Subject: BE/109/19 - Signed Designers Response to the RSA and DfS Engineer Comments

SUBMISSION TO WEST SUSSEX COUNTY COUNCIL FOR DEPARTURES FROM STANDARD

Project Name	BE/109/19/OUT Shripney Road, Shripney
Applicant Organisation	Highgate Transportation
Applicant Ref	1845/DfS/01
Highway Authority Ref	
Applicant Contact Details	Highgate Transportation Limited, First Floor, 43-45 Park Street, Bristol, BS1 5NL Contact name: Brad Loxley Phone: 01779 349 121 Email: brad.s.loxley@gmail.com
Date Submitted	11/02/2020

Fig. 6.2 - Extract from Transport Statement – Visibility Splays & Junction Arrangement

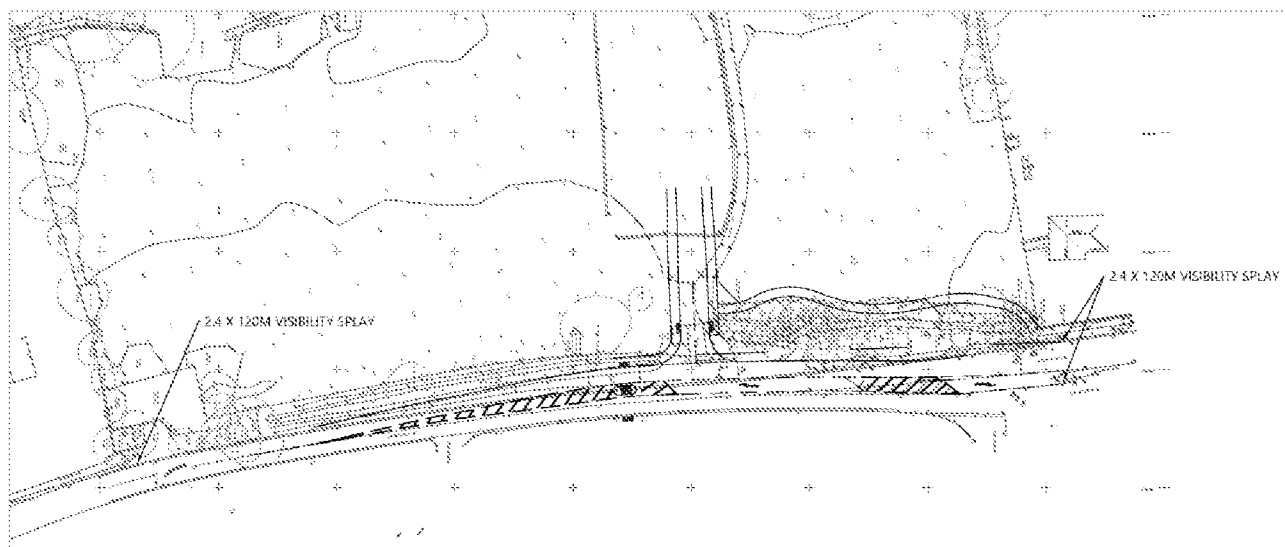
A Discipline	Road Geometry
Type	Visibility Splay to the south
B Relevant Standard(s)	The designer should simply mention the standard that deals with the situation, e.g. CD 123. A visibility splay of 2.4 x 124.2 metres should be provided to the south. This y distance is based on a design speed of 44.8 mph (85th percentile surveyed speed during January 2020 survey) and the equation $SSD = vt + v^2/2(d+0.1a)$ with a reaction time of 2 seconds and deceleration rate of 0.375g as set out in DMRB TD 42/95). This should be drawn to the nearside kerb, or to the centre line if a road feature prevents overtaking.
Clause	DMRB CD 109 Table 2.10, DMRB CD 123 Chapter 3 Visibility, DMRB TD 42/95. The applicable clause needs to be stated here. TD 42/95 has been superseded.

C	Difference Between Standard(s) and proposed design	The visibility splay to the south is shown to a point 0.5 metres from the central reservation kerblane. The x and y distances are in accordance with the standards at 2B. The designer should state that: The design proposes a y-distance of 120 m to the kerblane because of the need to preserve trees. CD 123 requires a y-distance of 124.2 m for a design speed of 44.7 mph.
D	Reason for Departure (overview)	This offset negates the need to remove approximately five highway trees from the central reservation. Isn't the reason for departing from standard related to the preservation of trees?
E	Associated Project Departures	Providing visibility offsets of up to 1.0 metre is acceptable practice on the road network.. In any case this row seeks associated project departures -- the designer should refer to associated departures.
F	Other Options Considered	Removal of highway trees in discussions with highway officer.

A	Safety	No implication expected? – Although the full visibility is not achievable to the kerblane as required by standards, it is achievable to a 0.5m offset into the carriageway. This is therefore not considered a significant safety concern for both motorists and cyclists. Motorcycles are wider than 0.5m. Cyclists will generally be travelling in lane one rather than the extreme offside of lane 2 and therefore well within the visibility splay; they will also be travelling at a lower speed. Drivers are also located at more than 0.5m from the kerblane. Full inter-visibility with motorists at the access road is achievable
B	Congestion/ Delay	No impact
C	Environmental / sustainability	Preservation of around 5 highway trees. Expand
D	Capital and whole life cost/value	Small cost saving in not removing trees. Expand
E	Accessibility	No impact
F	Integration	No impact
G	Structural	No impact
H	Network resilience & Maintenance	As existing
